File No: SF17/34011
Job ID: DOC17/375700
Your Ref: SSD 7372 MOD 2

RE: Heritage Council of NSW comments on the modification for the redevelopment of O'Connell Street Public School (SSD 7372 MOD 2)

It is noted the proposed changes comprise of the addition of ten photovoltaic panels to the northern side of the new school hall roof and the extension of a rooftop plant platform on Building B with an associated louvered screen and balustrading.

Figure10: North Elevation showing the Proposed location for the extension of the Plant Platform.

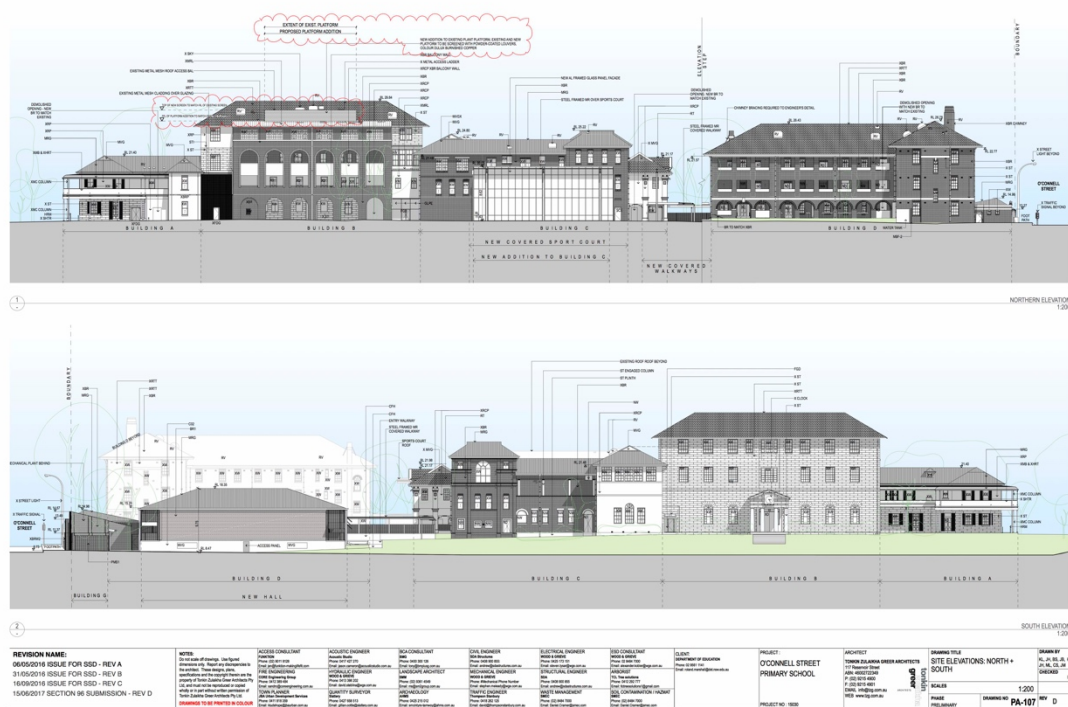
It is also proposed to increase the extent of the mechanical services and louvres to the roof of Building B. The proposal will effectively double the footprint of mechanical services currently on the roof and will increase the width of the existing plant platform from 2.4m to 7.7m. This increase in the footprint and the width increases the bulk of the structure dramatically and therefore increases the visibility of the structure when viewed from the north, east and west.

This proposal is in conflict with policy 21.1 of the 1994 Conservation Management Plan for the site drafted by Peddle Thorp Architects. The policy states that the addition to the main school building (of which the roof forms part of) is of high heritage significance and the original exterior should be recovered by the removal of intrusive elements such as the mechanical service elements on the roof.

Therefore, the proposal to increase the extent of mechanical services on the roof of the building B is not supported. It is recommended that further options be considered by the proponent with the aim of removing the mechanical services from the roof entirely and a

revised proposal be prepared in consultation with the Heritage Council or its delegate prior to any approval being issued.
